MODIFICATION REQUEST:
Mixed Use Development
44-46 Walker Street, Rhodes
MP 10_0105 MOD 1

Director-General's
Environmental Assessment Report
Section 75W of the
Environmental Planning and Assessment Act 1979

September 2012

4 ELEVATION
BLDG B - WEST
1 : 200

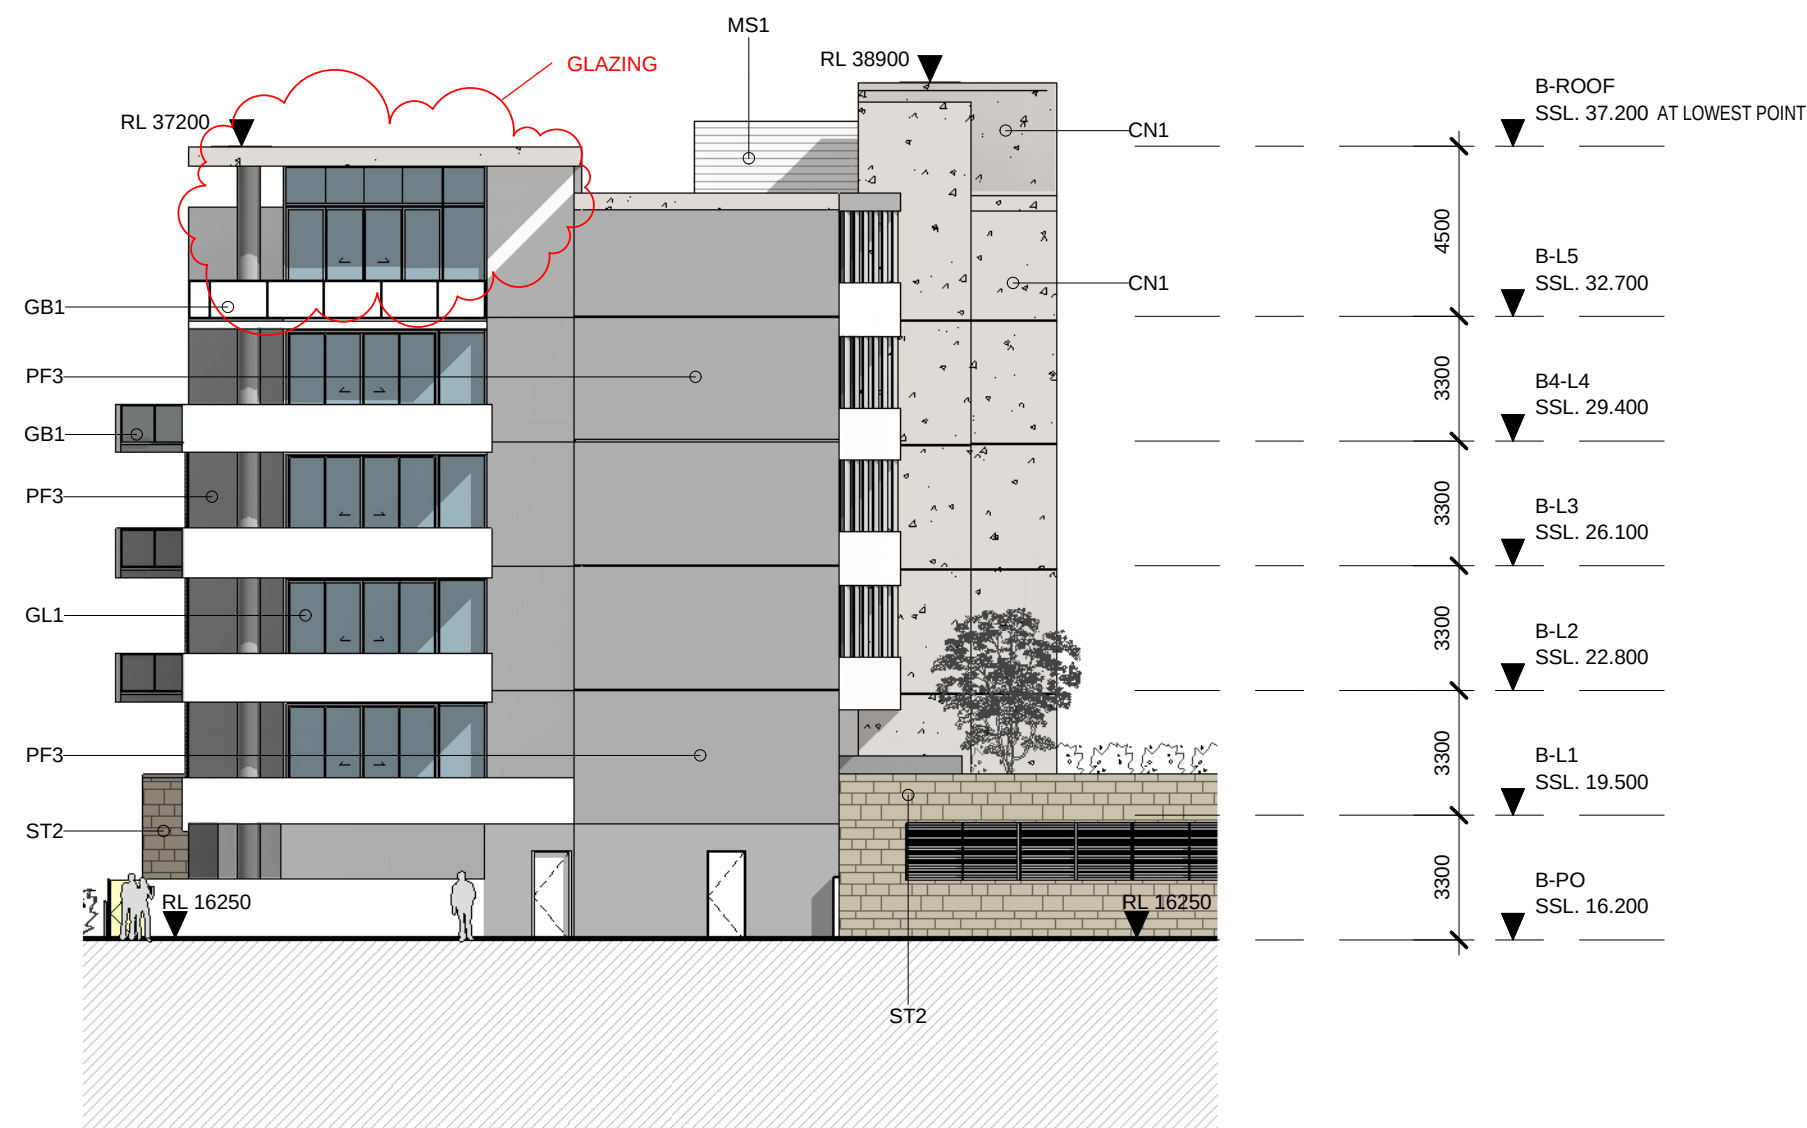
- Levels 2 to 5 – revisions to the southern access balcony.
- Minor changes to the stair core at two locations.
- Modification of glazing elements at apartment 5.01 (level 5 only).

The revisions to the southern access balcony to apartments at levels 2 to 5 are proposed in order to provide additional privacy for building occupants and improved amenity. The department does not raise any concerns with the proposed minor amendments to Building B.

Elevations - BLDG C
North & South

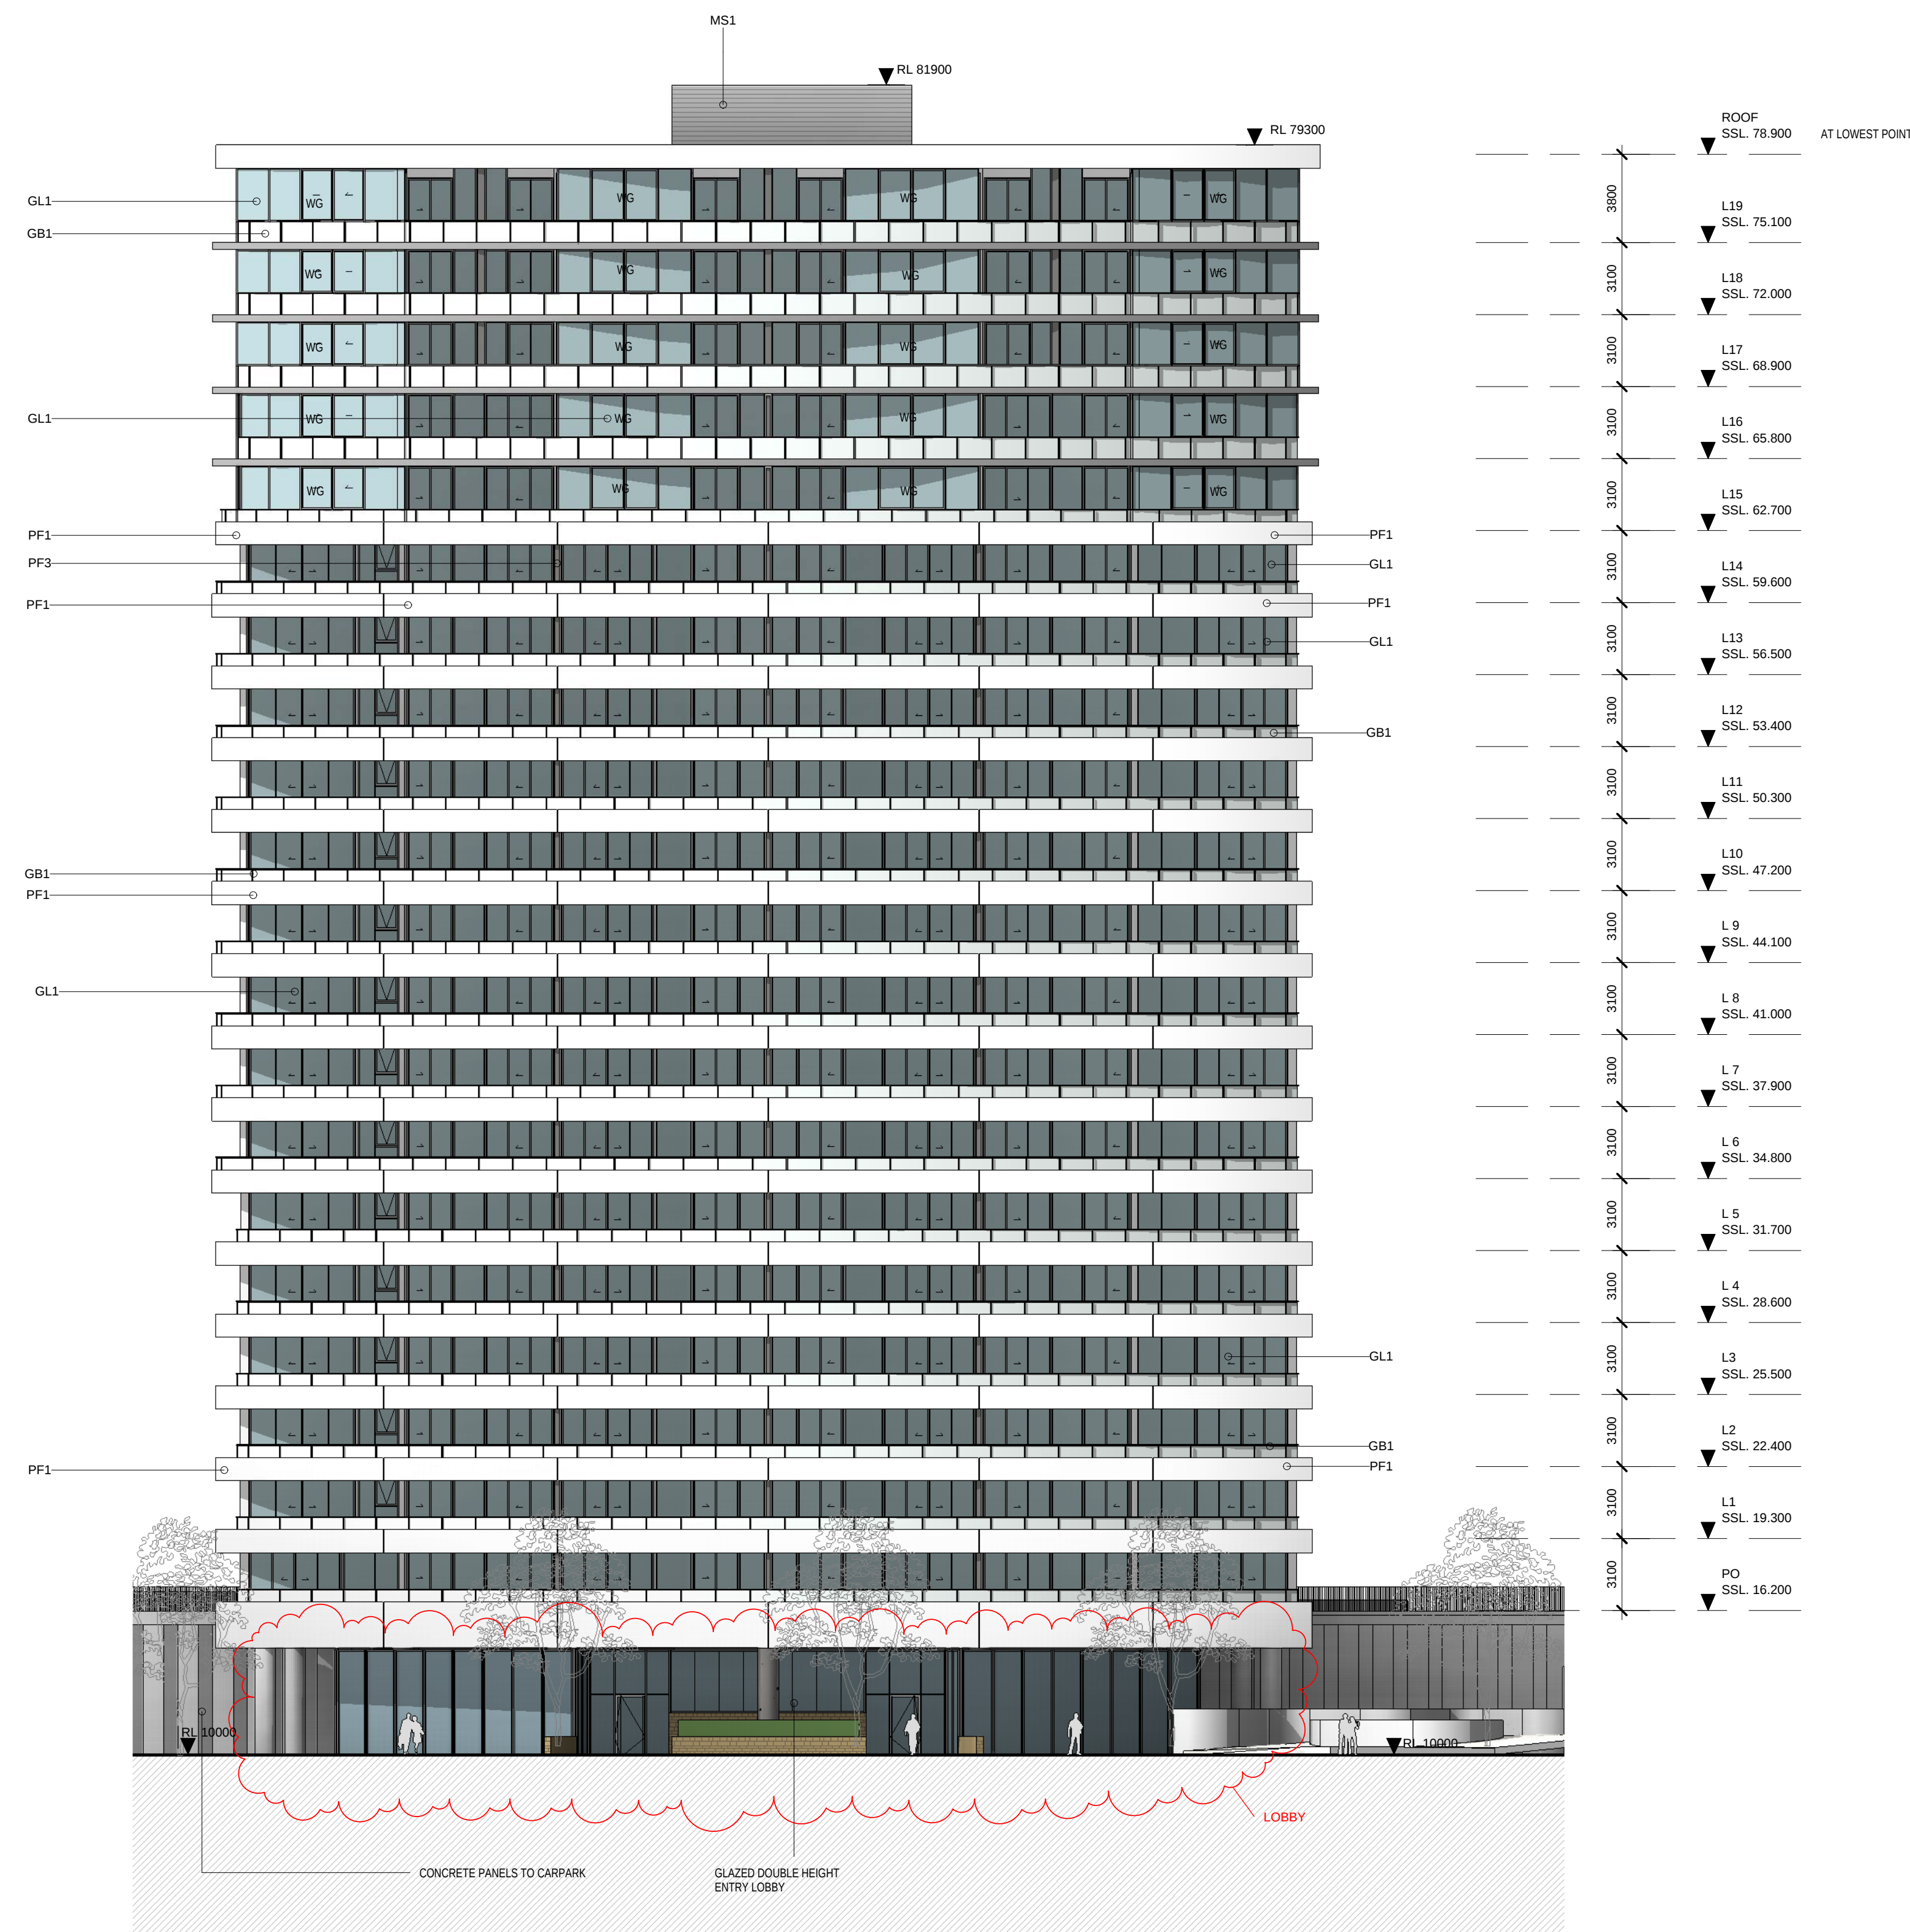
- Modifications to the glazing treatments of levels 16 to 19 at the northern and southern elevations.
